DELEGATED HOUSEHOLDER DECISION

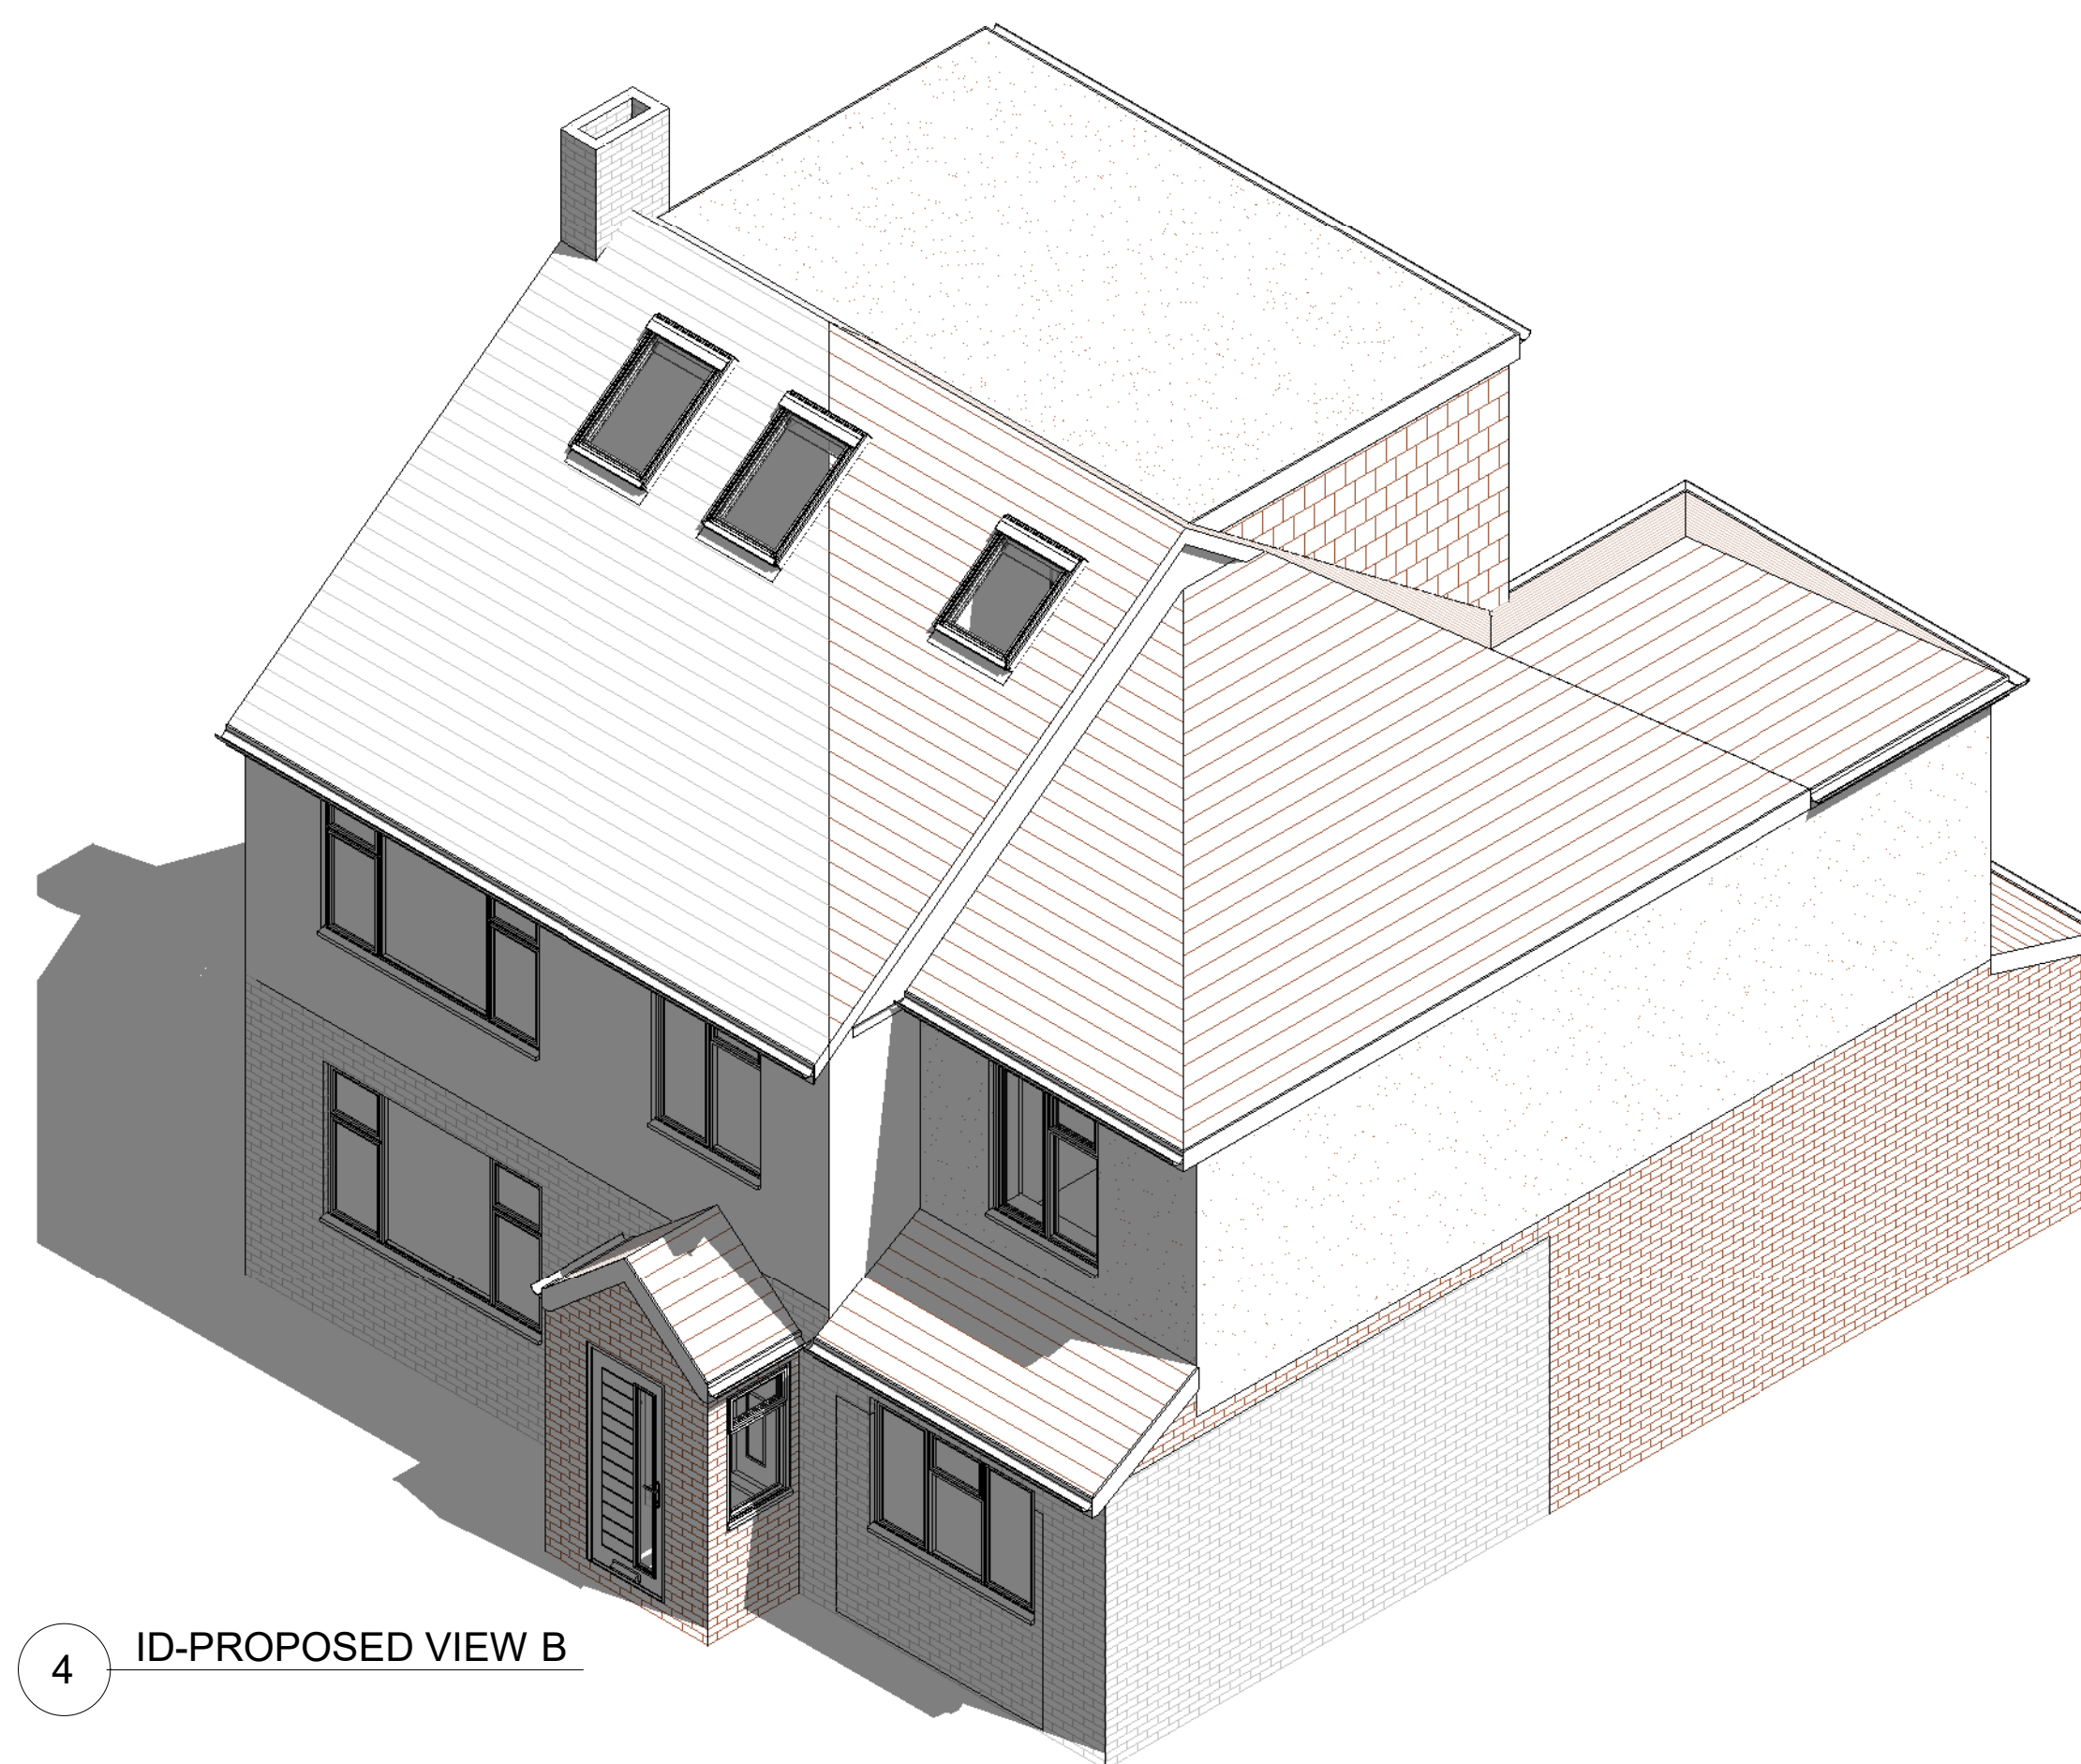
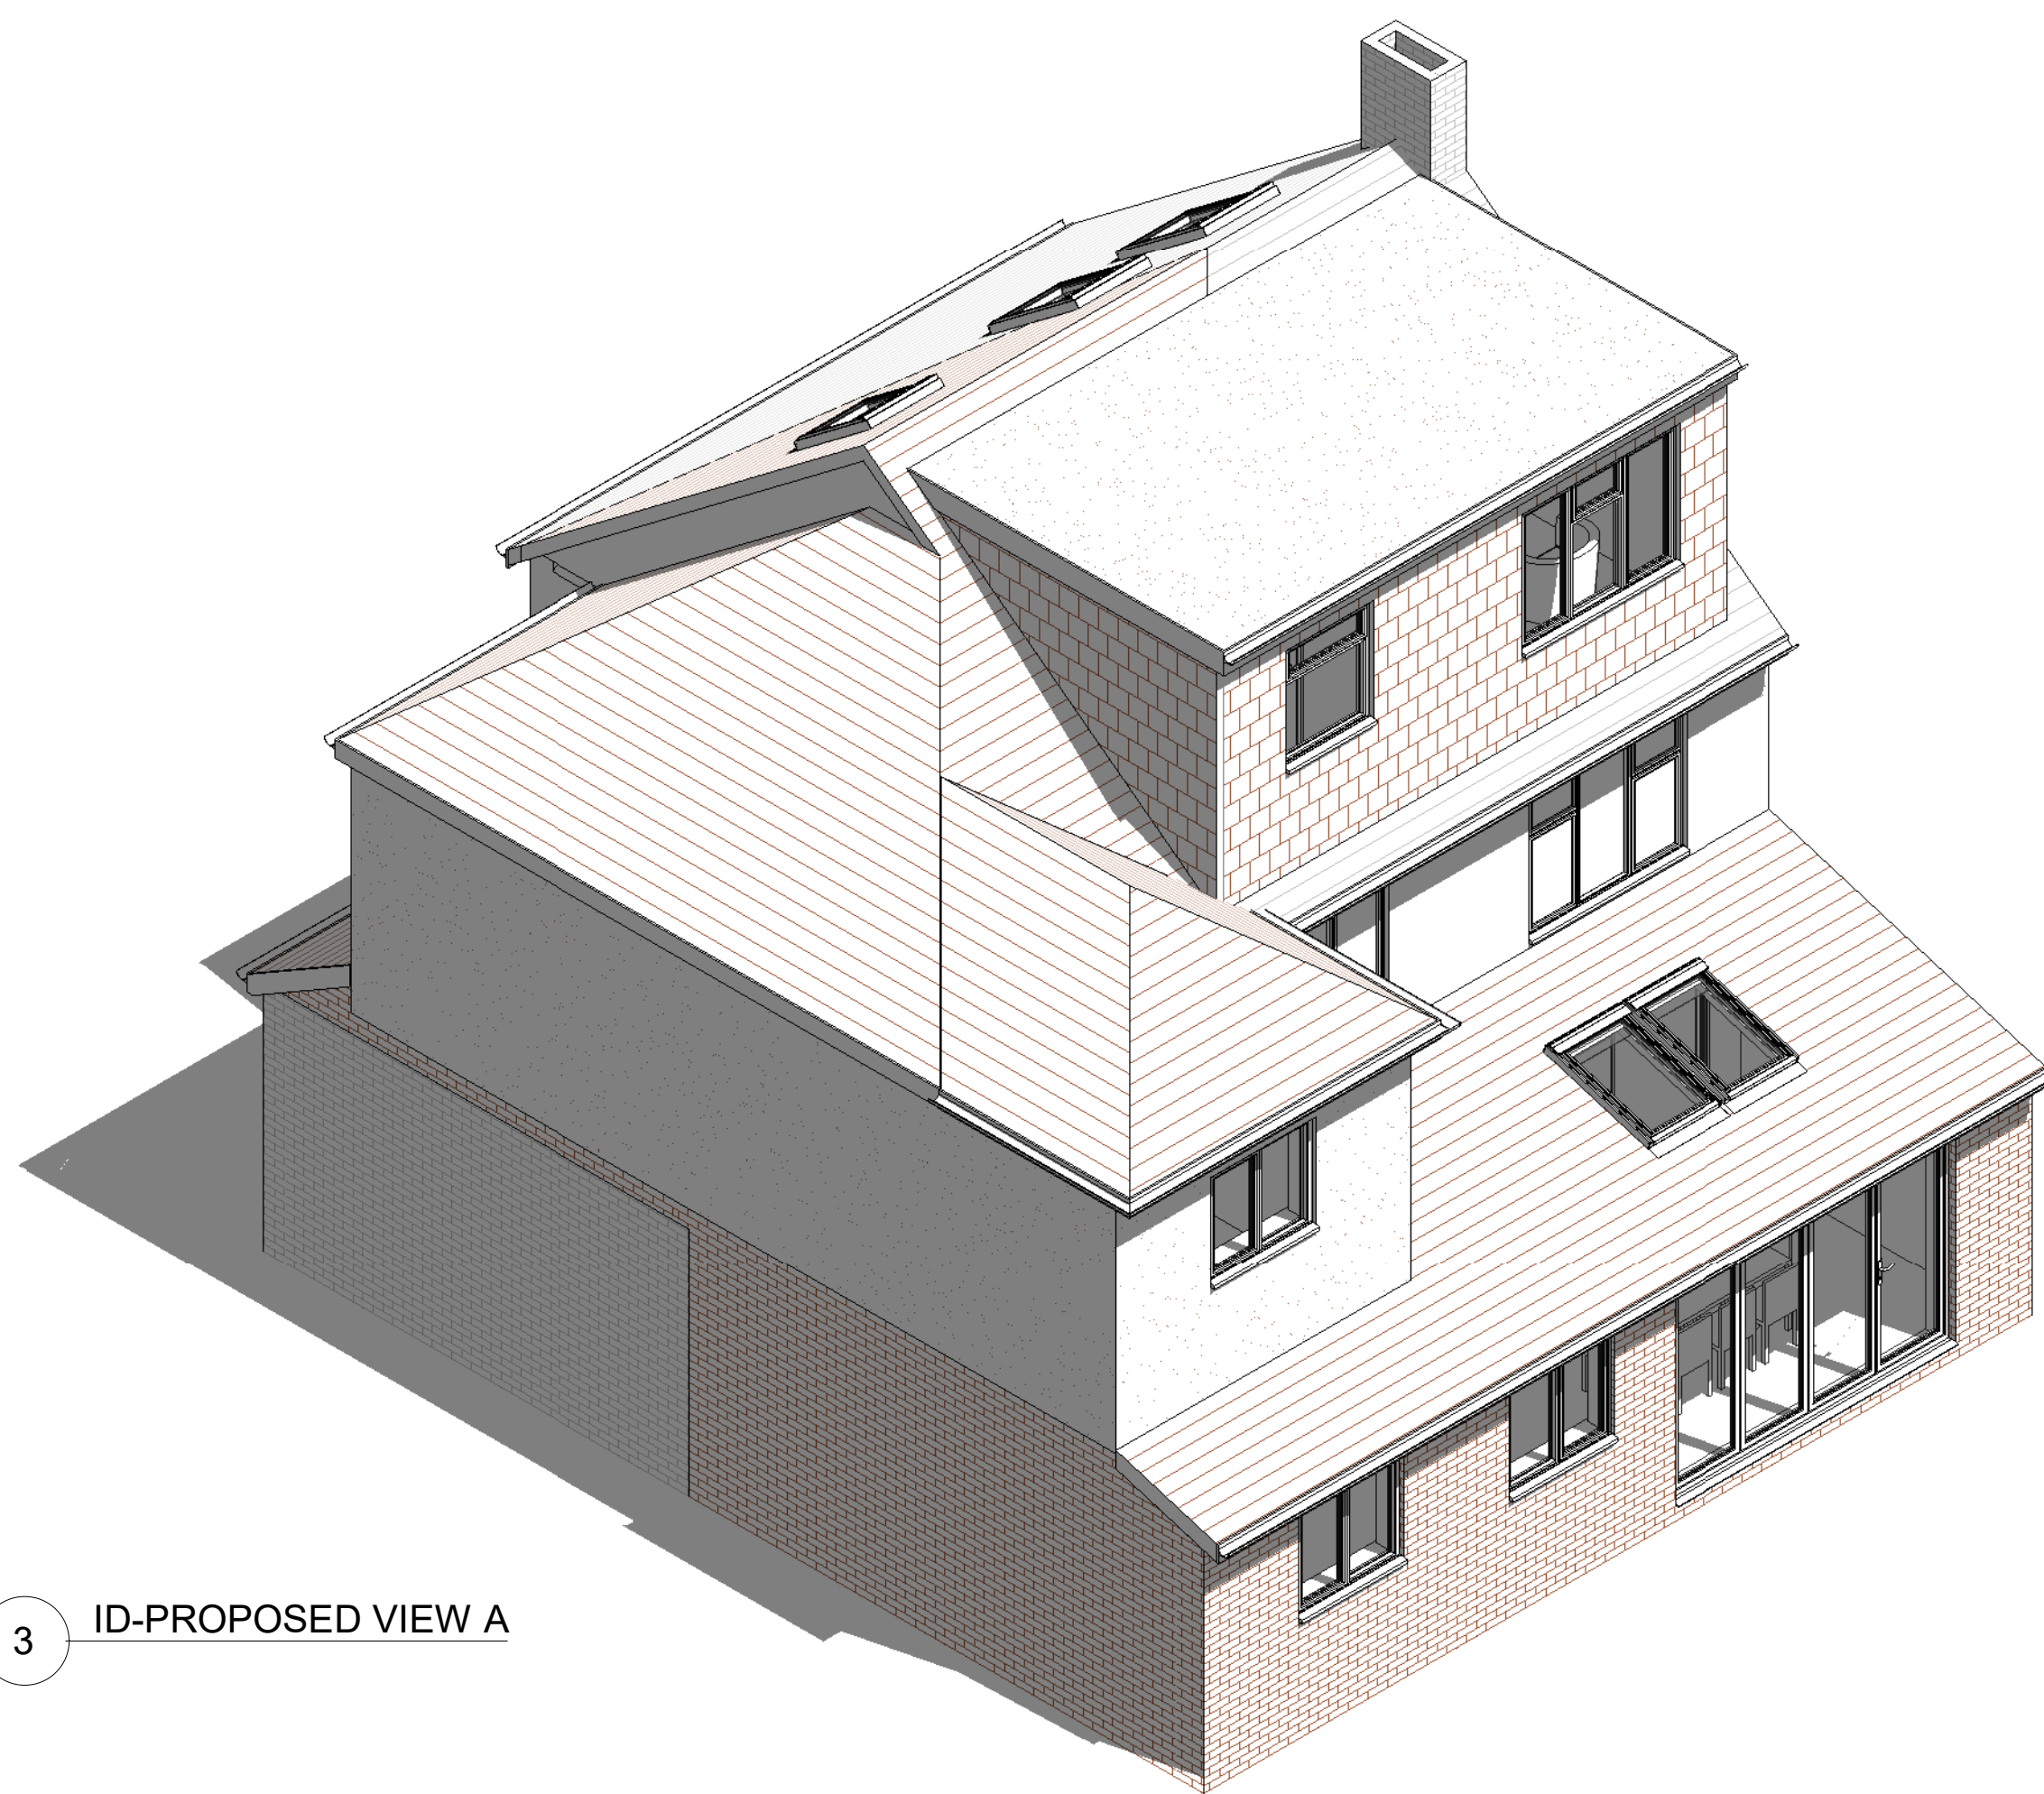
The application site features an existing garage which extends approximately half way the length of the host dwelling. The application proposes a part single, part two storey side extension utilising the existing footprint of the garage. The single storey element of the side extension (together with existing garage) would measure a width of 3m, a length of 10.7m (to the rear) and would feature a lean-to roof up to a height of 3.3m. The existing garage would be converted to a 'Reception' and a window would replace the existing garage door. The first floor side extension would measure a depth of 3m, a length of 8.7m (to the rear) and would feature a hipped roof measuring a height of 7.8m. The proposed first floor side extension is set back 1m from the front building line and set down 0.6m from the ridge, however there is not set-in from the side boundary. In this regard, the proposed part single, and proposed two-storey side extension would fail to comply with Policy DMHD 1.

Turning to the rear, the application proposes a part-single and part two-storey rear extension. The single storey rear element would measure a depth of 3m, a length of 9.4m and will feature a lean-to roof up to a height of 3.5m. The first floor rear would protrude 2m from the rear building line, measure a width of 3.3m and feature a pitched hipped roof up to a height of approximately 6.8m. It is acknowledged that the parameters of the rear extension complies with Policy DMHD 1.

The application also proposes the conversion of loft space into habitable space to include a rear dormer, hip to gable end conversion and 1 No. additional roof light. The proposed rear would measure a width of 5.8m, a depth of 3.4m and a flat roof height of 2.6m. Policy DMHD 1 states that the Council would not support overly large roof extensions, and roof extensions should not exceed more than two-thirds the average width of the roof. The proposed rear dormer would exceed more than two thirds the average width of the roof and would fail to retain a substantial element of the existing original roof slope. The proposed hip-gable roof form would diminish the symmetry with the attached pair. The proposed variation is further exaggerated by virtue of the proposed two-storey side extension. The proposed two-storey side hipped roof extension in combination with the hip to gable extension and overly large rear dormer appears obtrusive and unsympathetic within the street scene and has an unacceptable impact upon the host dwelling. Together both the roof and first floor extensions would appear visually awkward and at odds with the original house design and prevailing character along this section of the street.

The proposed development would substantially alter the appearance of the property. The significant increase in bulk and mass by virtue of the part-single, part two-storey side and rear extension, together with the hip to gable conversion and large rear dormer would result in an incongruous development. It is considered that the proposed development, when viewed as a whole, would be completely disproportionate and unsympathetic to the original architectural composition of the host dwelling. Thus, resulting in the proposed development having a harmful impact on the original dwelling, the attached pair, and the wider street scene.

To conclude, the proposed hip to gable conversion, large rear dormer together with the two storey side/rear extension, by reason of their cumulative size, scale, bulk, height and design (including the proposed relationship with the gable and hipped two-storey side), would result in a disproportionate, visually obtrusive and incongruous form of development that would be detrimental to the appearance of the original host dwelling, and would cause harm to the character, appearance and visual amenities of the existing street scene. The proposal is therefore contrary to Policies BE1 of the Hillingdon Local Plan: Part One - Strategic Policies (2021), Policies DMHD 1 and DMHB 11 and of the Hillingdon Local Plan: Part Two - Development Management (2020), Policy D3 of the London Plan (2021) and Chapter 12 of the National Planning Policy Framework (2023).
